| Application number: 2024/90620 | |
| What is the application for: | Erection of rear extension and front and rear dormer extensions (within a Conservation Area) |
| Address of the site or building: | 5A Greenway, Honley, Holmfirth |

Objection to: Planning Application No. 2024/62/90620

Rear Elevation S
1 : 100

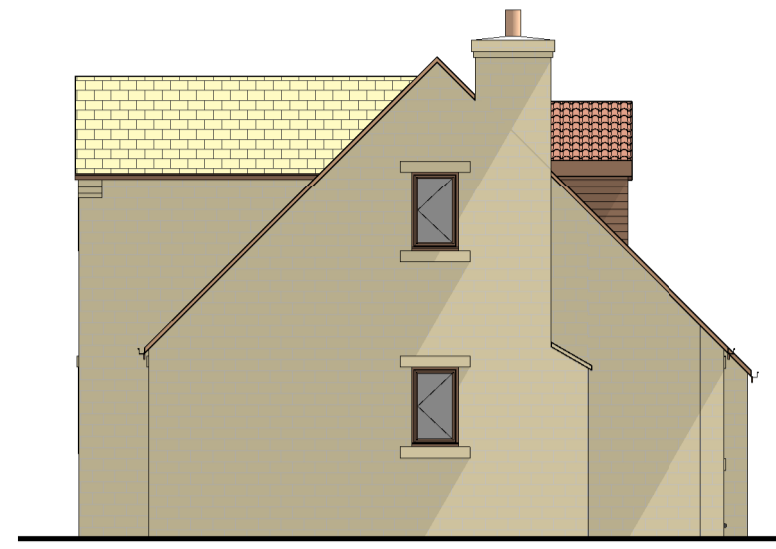
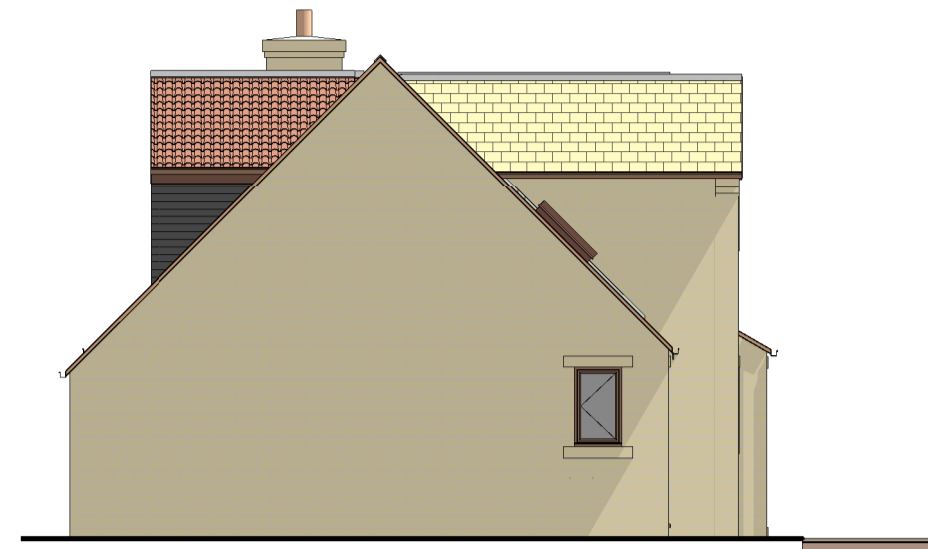
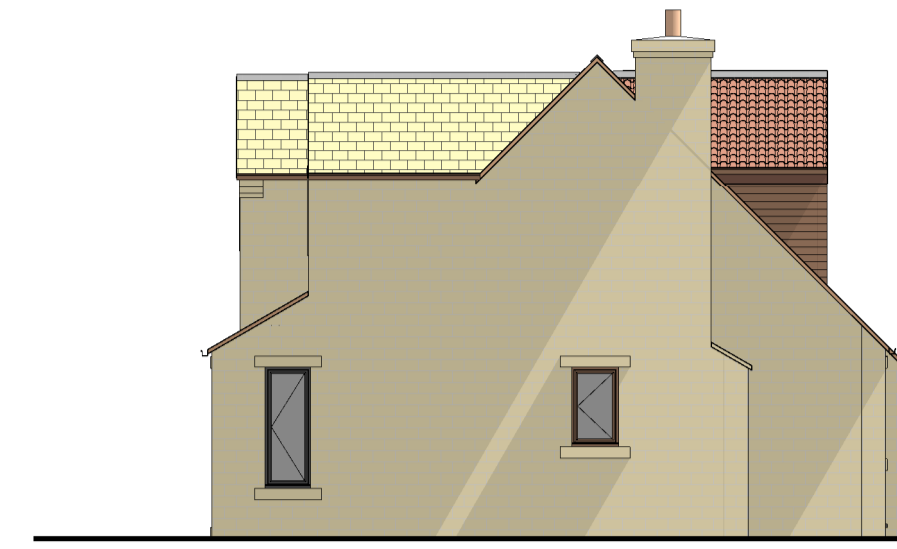
- f) The architect's plan on Kirklees website does not carry any dimensional information but it appears from the existing and proposed sketches (rear elevations) that the development will increase the proposed roof line by approximately 300/500mm, aligned with the chimney top and also the pitch of the roof will change significantly from being in-line with Nos 6 and 5 Greenway bungalows to as indicated on figure 1 below:-

- ii) Key Design Principle 1: Local character and street scene. - It is clear that No 5A was originally constructed as a dormer bungalow to maintain the roof lines of the adjacent bungalows along Greenway. The proposed alteration will clearly conflict with this and create a much larger mass (see fig. 1).

- iii) Page 9 Building line - "Where a street or group of buildings have a clearly defined building line this should be retained"
- iv) Key Design Principle 2: Impact on the original house. Para 4.5 - "The materials, design, **roof pitch**, and detailing should normally match the existing house detailing. The proposed roof pitch clearly does not.

The proposed application will produce a large slab of machined stone wall much higher than currently and close in the open space of Greenlea Court. Currently, the sloping roof of the existing dormer bungalow flows away from the Court and exaggerates the space.
- vii) Key Design Principle 7: Outdoor space. - "Extensions and alterations should ensure an appropriately sized area of outdoor space is retained."

- i. No dimensional details are shown on the plans to clarify height and shape of the roof.

First Floor Plan
1 : 100

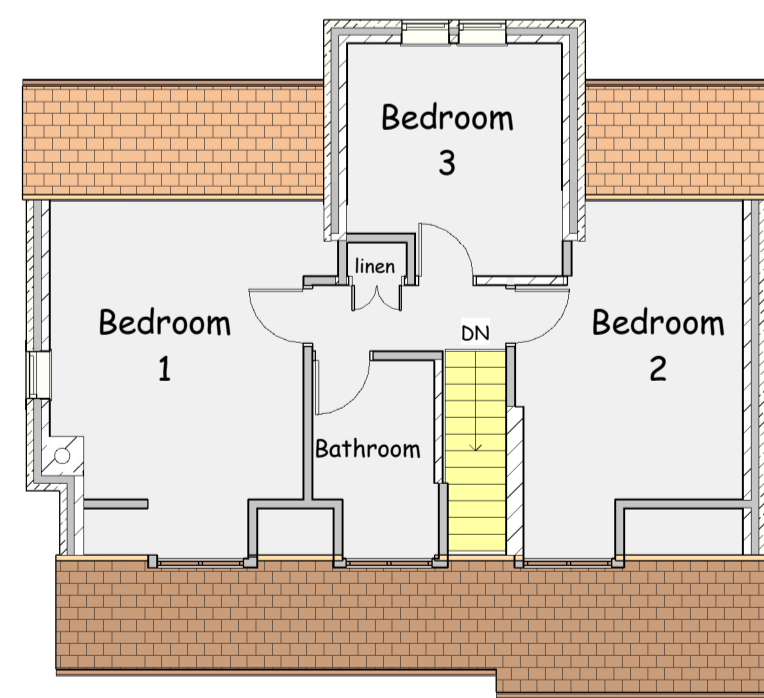
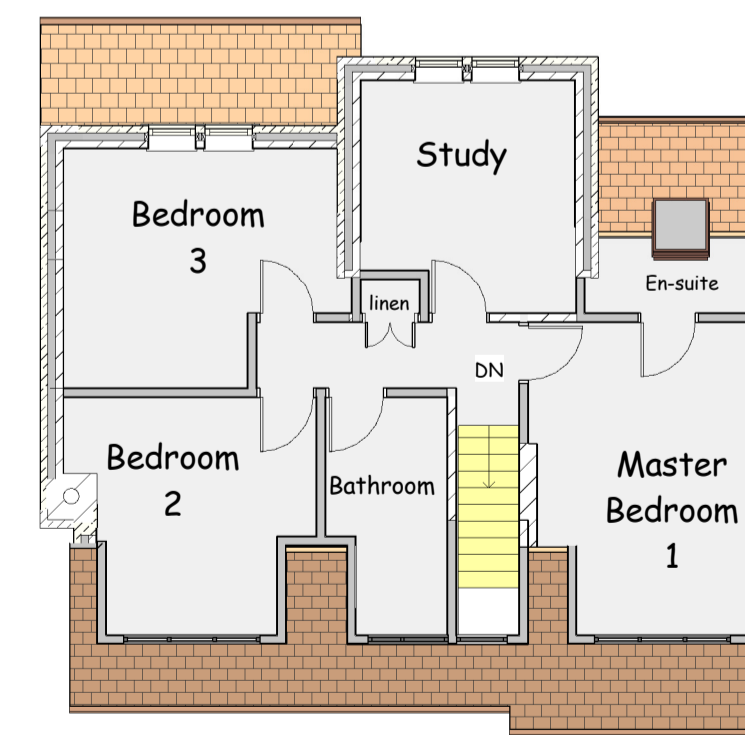
- a) The introduction of a fourth bedroom includes two windows at a high level overlooking bedrooms and lounge in No 1 Greenlea Court.
 - b) The inclusion of a "sunroom" in such a small place will not allow sunlight into the sunroom due to the existing hedge around the garden and it is highly likely that these quite beautiful hedges will be removed. This will open up all of Greenlea Court and destroy the current privacy which we enjoy.

- iv. The previous application was for 4 bedrooms which would clearly affect parking requirements, however, this application is for 3 bedrooms and a first floor study which will undoubtedly become a 4th bedroom thereby further affecting car parking arrangements.

- v. The introduction of a study (which was previously bedroom 3) and the addition of another bedroom (which is now called bedroom 3) includes two windows at a high level overlooking bedrooms and lounge in Nos 1&3 Greenlea Court.

Block Plan
1 : 500

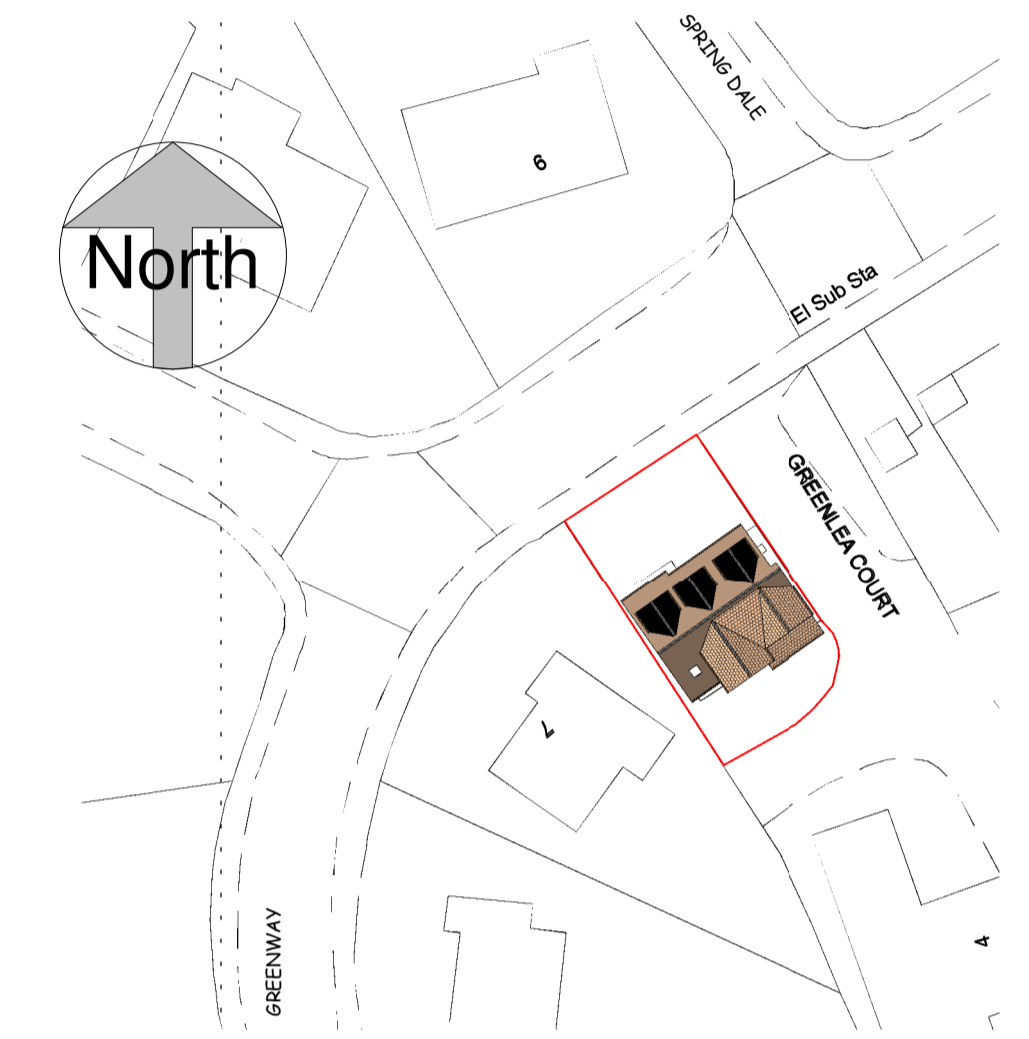
1. The map shown within the above noted application indicates that the land area associated with No 5A includes the whole of the Entry Road including the garden area of No 1 Greenlea Court adjacent to the Entry Road.

This is incorrect as the Land Registry shows that the boundary between No 5A and No 1 lies along the centre line of the Entry Road.

2. The map shown within the above noted application also indicates that the land area associated with No 5A includes the whole of the Turning Area.

Again, this is incorrect as the Land Registry shows that the boundary between No 5A and No 4 lies along the centre line of the Turning Area.

- a) The plan shown in the Kirklees website is incorrect when compared to the Land Registry documentation and should be corrected showing where the official boundaries are.

The owner of No 5A states that this land area (turning area) and whole entry road of Greenlea Court (including the garden of No 1 Greenlea Court) is within his property boundaries and this shown on the Kirklees map provided. However, the official Government Land Registry document dated 06/1989 shows this to be incorrect and that No 5A boundaries lie along the centre of the entry road and turning area. No 5A Greenway has a garage and driveway, sufficient for 2 parking spots. In order for this application to succeed a third parking spot should be created on Greenway and the turning area should remain as it has been for 30+ years.
